DEVELOPMENT REVIEW BOARD
SUPPLEMENTAL SUBMITTAL

PROJECT NO. 2022-006547

DESCRIPTION: DRB - Site planning 2nd resubmittal city comments response

RE: Panda Express – S8-22-D8582
10126 Coors Blvd. NW
Albuquerque, NM 87114
RE: DRB Planning Review – 2nd Resubmittal
DRB Project Number: 2022-006547
App. Number: SI-2022-00216

NORTH-WEST ELEVATION 2
 Scale= 3/16" - 1/0" A-202

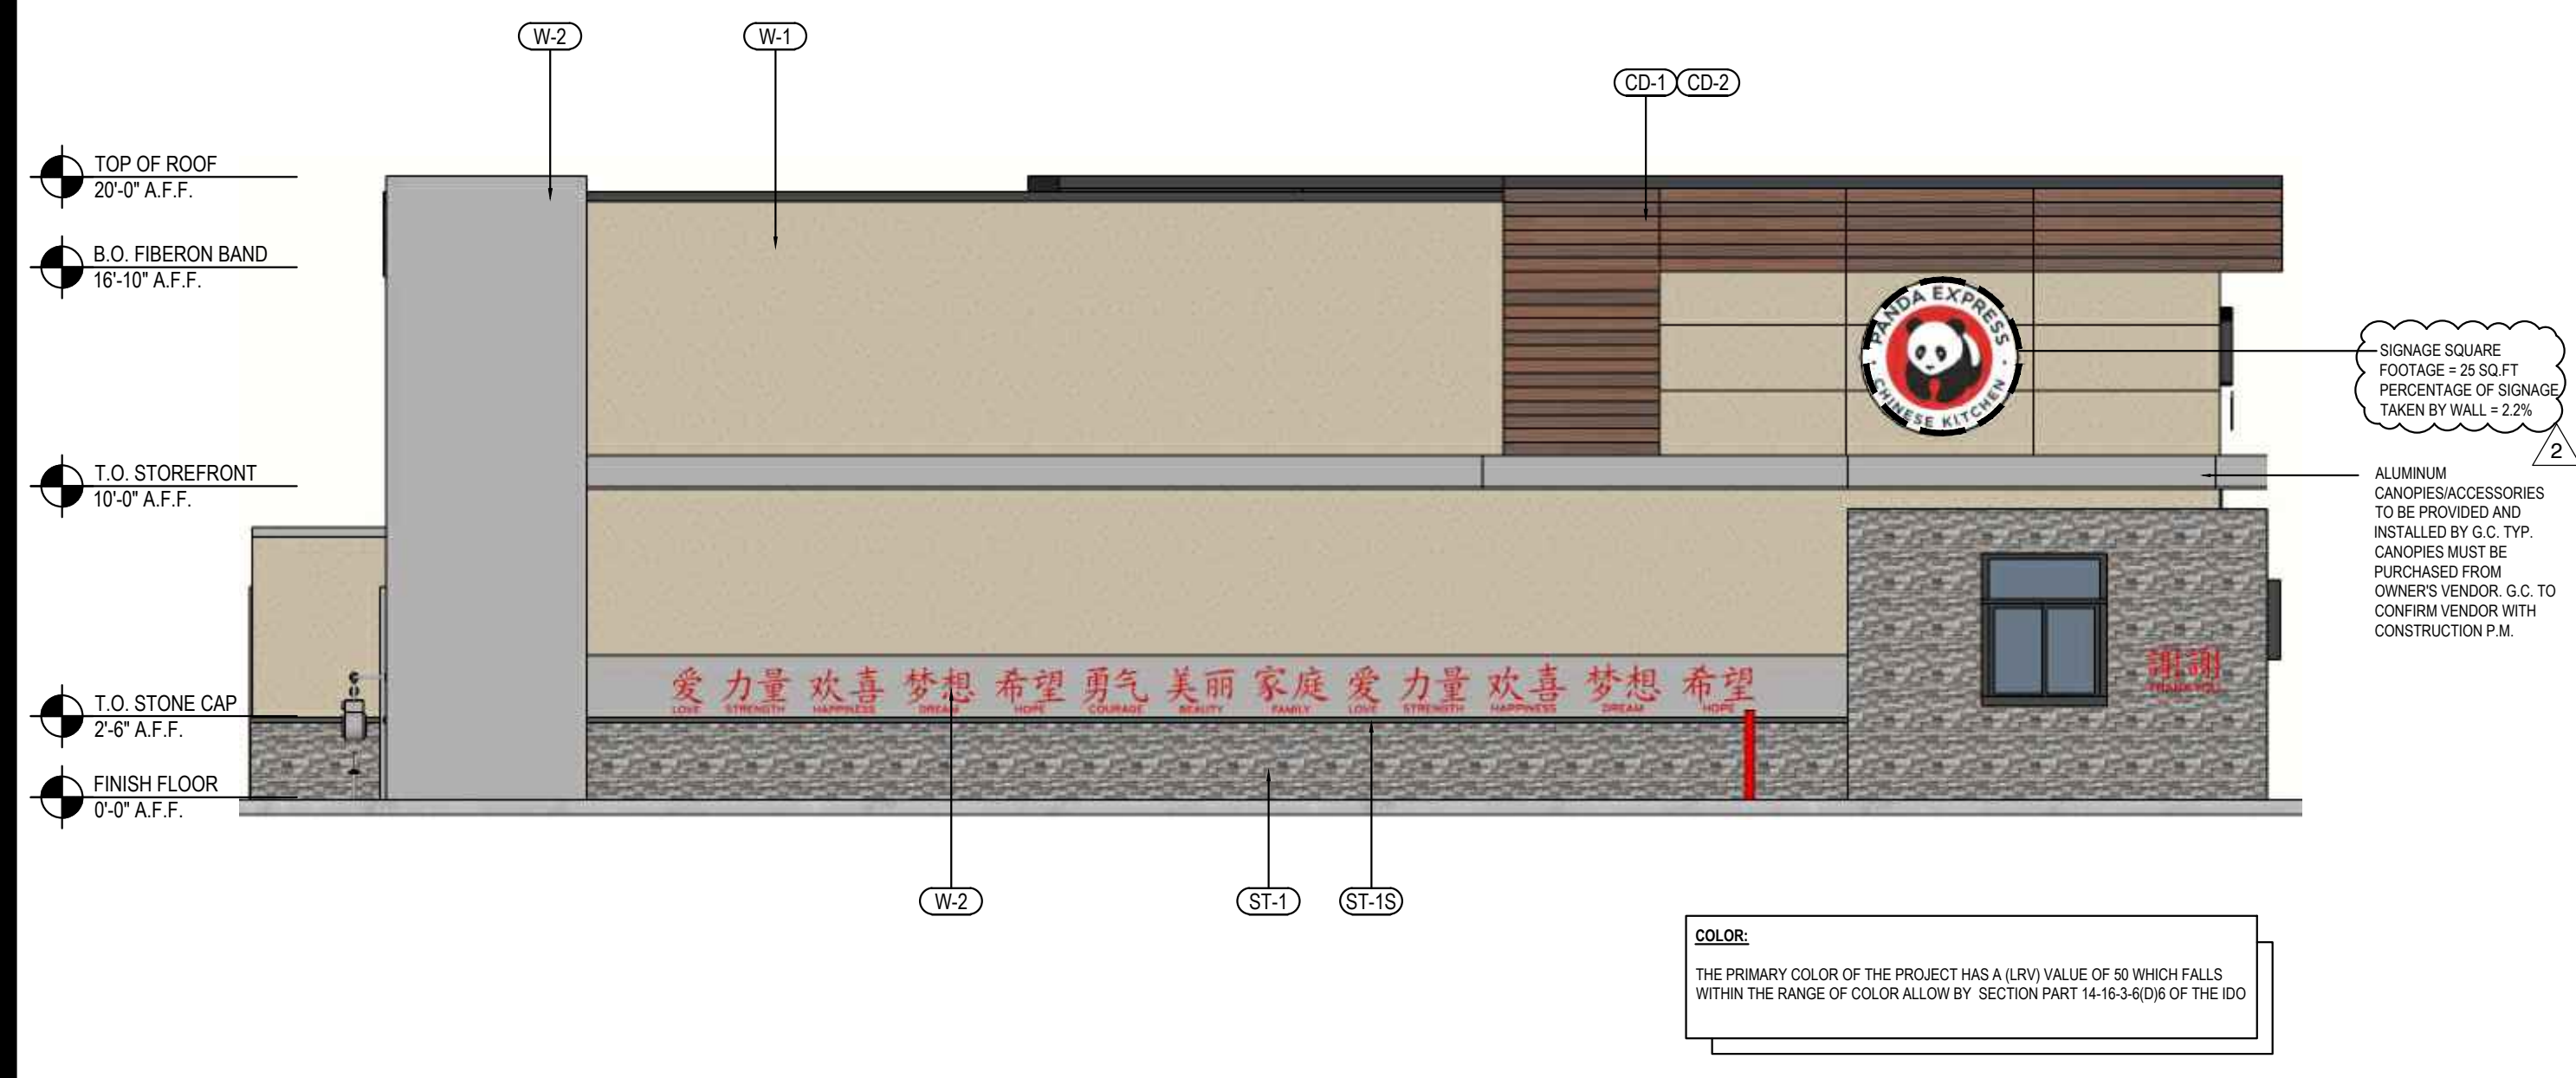
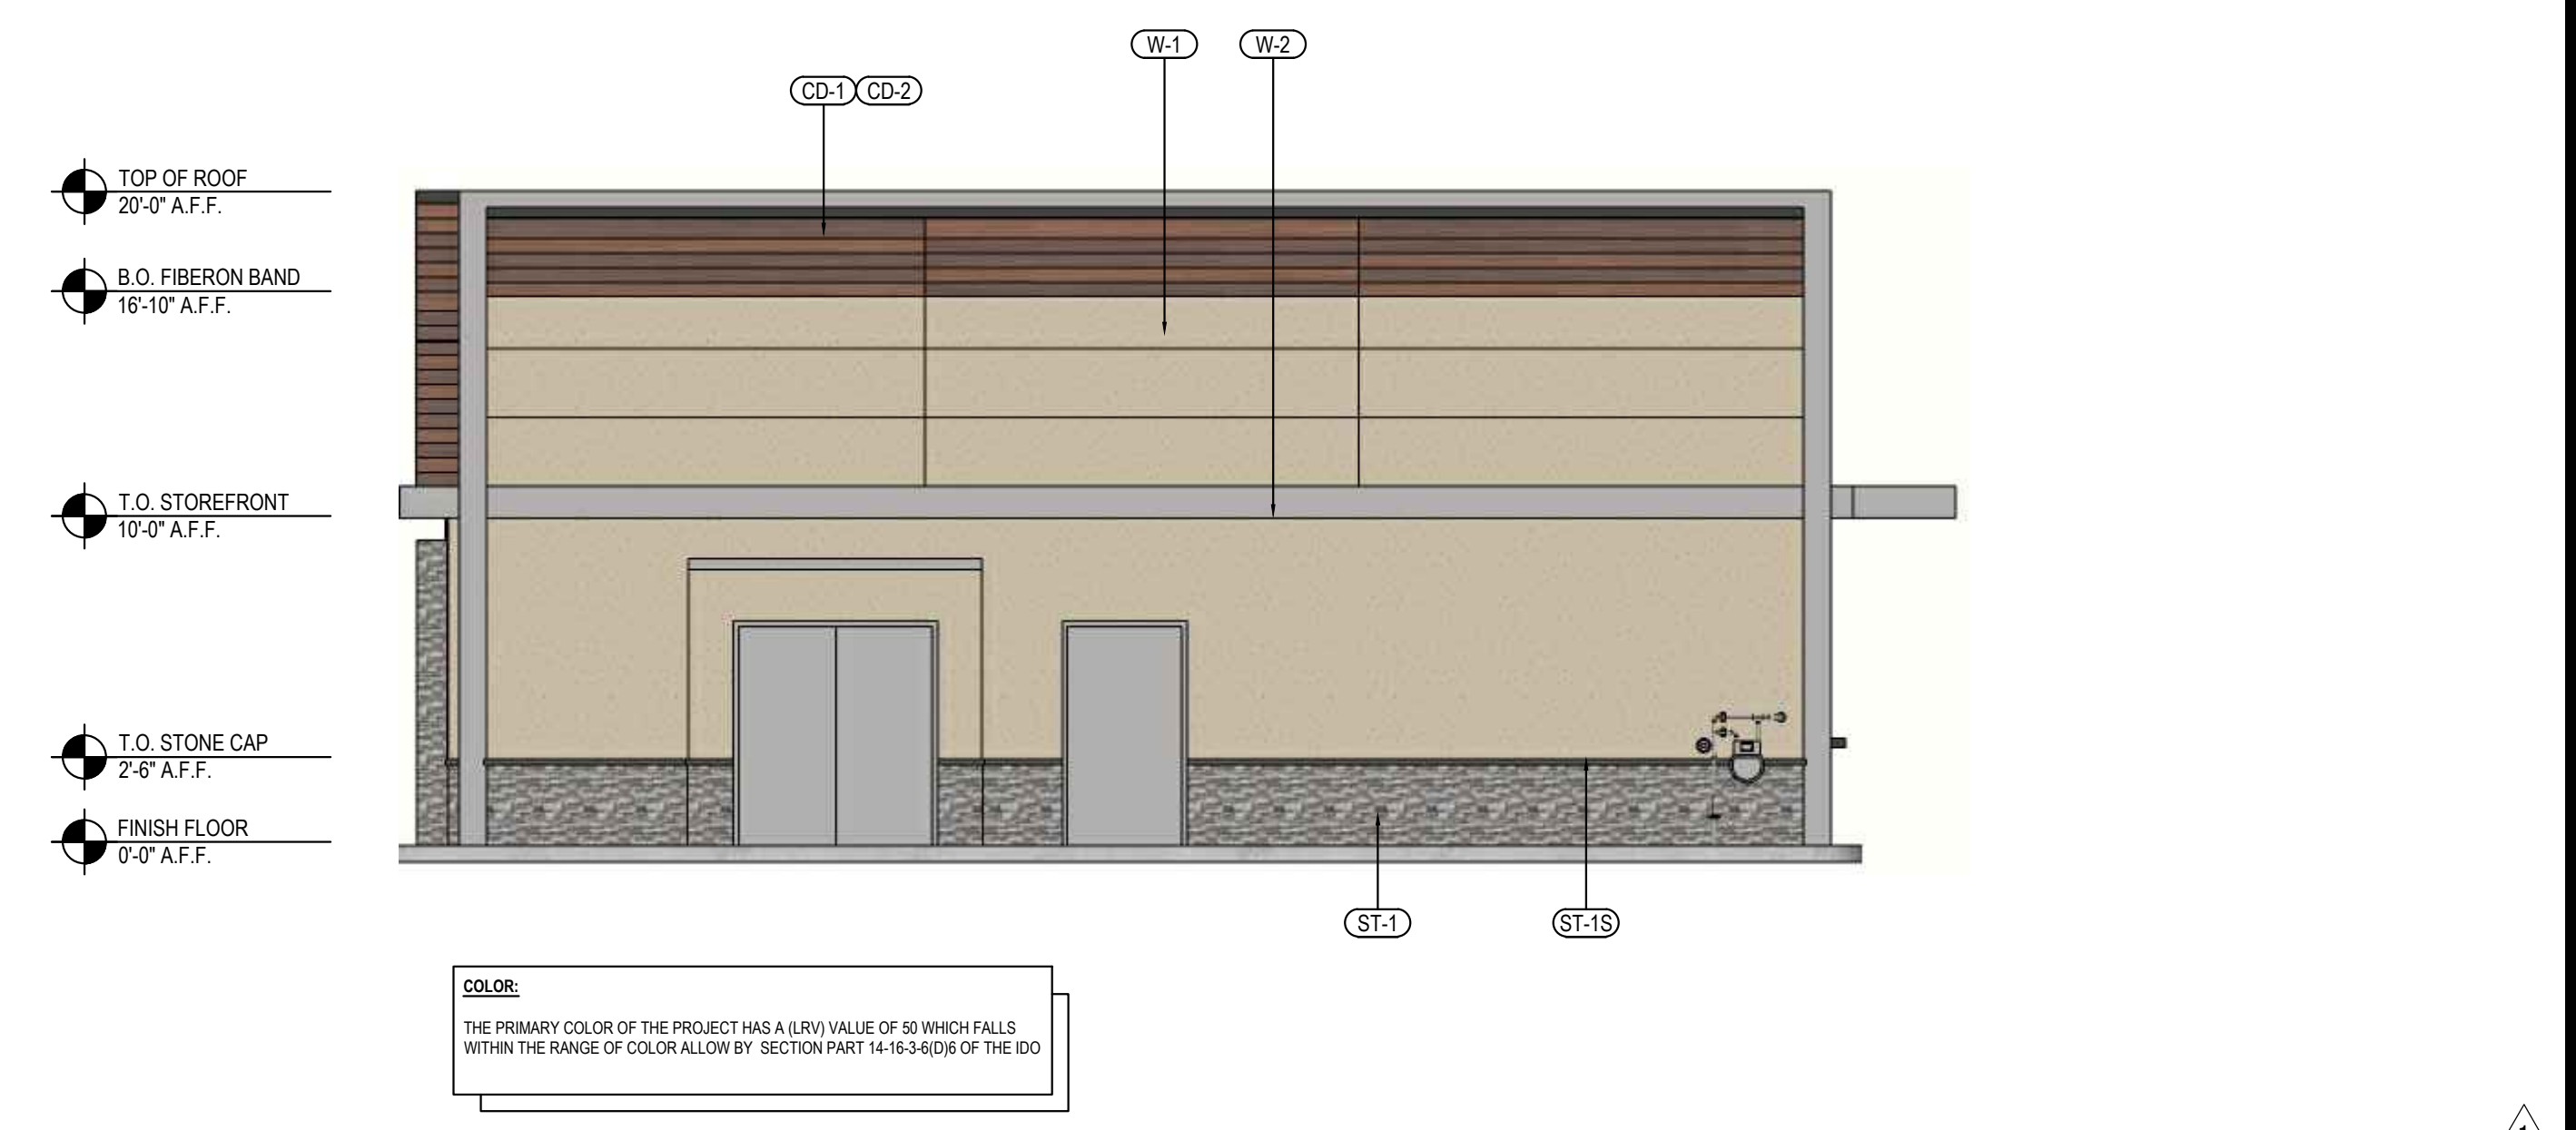
- Update 4/4/22 - The Building Design requirements of 5-11(E) are met with the exception of the requirement to provide ground-floor transparent windows along at least 30% of the length of the façade. A 10% Deviation from that requirement has been applied for to Code Enforcement.
Response: Refer to detail 2/A-202 for information. Total street facing surface area is 976 sq.ft. and 30% of the required transparent windows and/or door is 292 sq.ft. Panda is proposing 264 sq.ft. which is 27% of the required. Per IDO 6-4(P) Deviations Table 6-4-1: Allowable Deviations, Panda is requesting a deviation to the IDO standards on any other numerical standard of 10%. Per this deviation, the façade is 3% within the required 10% allowed on the "Any other numerical standard" per this table.

- The % of the façade taken up by the wall signage must be included.
Response: Refer to sheet A-202 for the percentage of façade the taken by the wall signage. See detail 2/A202 for the Northwest elevation signage is 3.4%, detail 4/A202 for Northeast elevation signage is 2.5% and detail 3/A-202 - Southwest elevation signage is 2.5%
